KITTITAS COUNTY

MEMORANDUM

SUBJECT: Hein Short Plat SP-20-00004

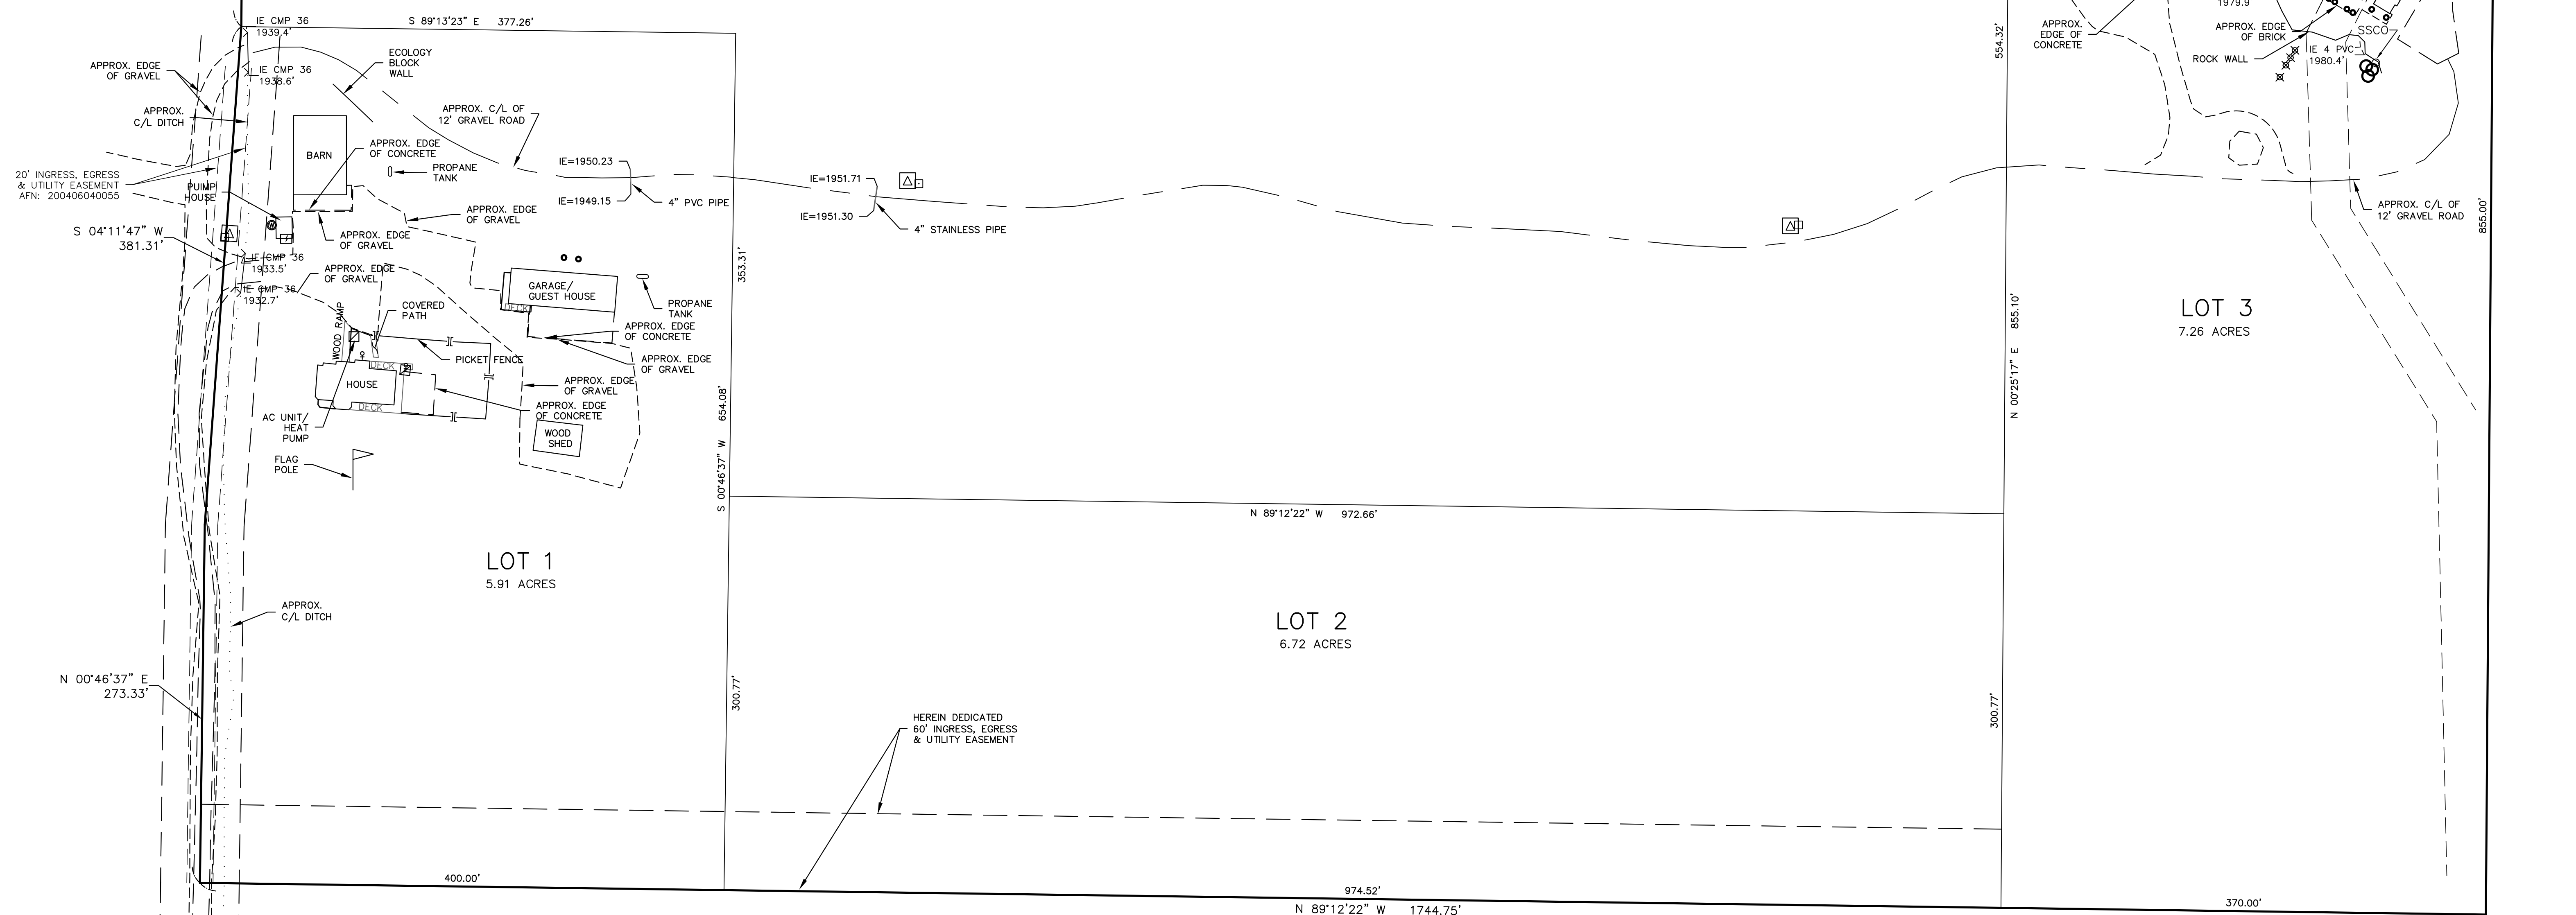
8. Easement Correction: The 30' access & utility easement crossing Lot 3 must be amended so the home does not encroach upon the easement.

AIRPORT ROAD SHORT PLAT APPLICATION

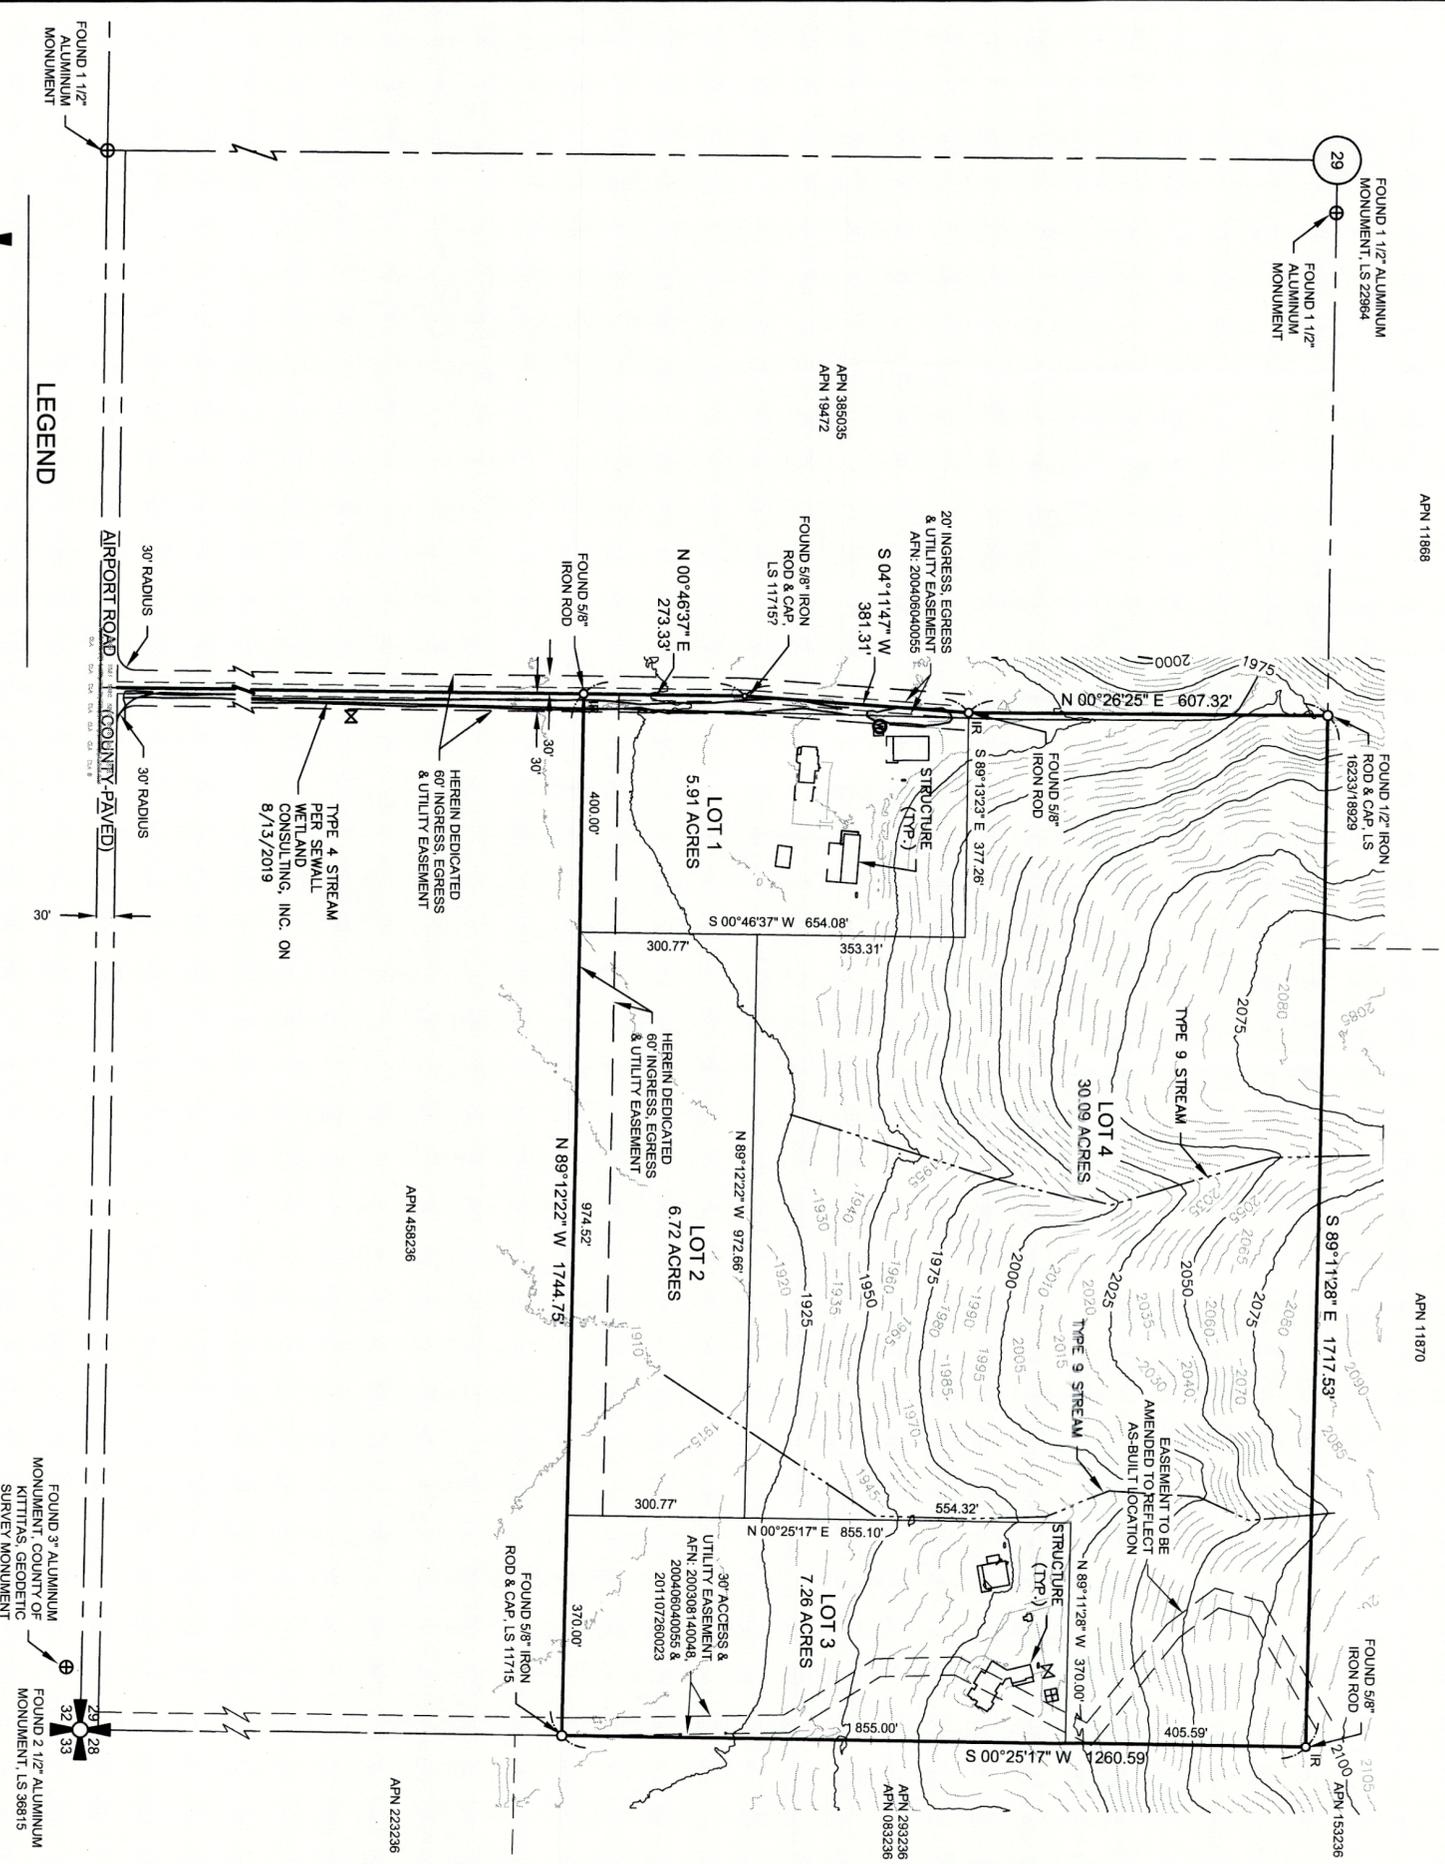
1. Include a surveyor's stamp and signature.
2. Include the requirements of RCW:332-130-145

1. Applicant is notified that basis of bearing, survey procedures, set corners, surveyors statement, auditors statement, will need to be addressed on the final submittal.
2. Ties to found section corners to be included
3. Both sides of county right of way to be shown on final
4. Easement shown as herein dedicated to be mathematically retraceable on final.
5. It is assumed that the found evidence was held, despite discrepancies with the record description. As such, a note explaining surveyors opinion would prove valuable.
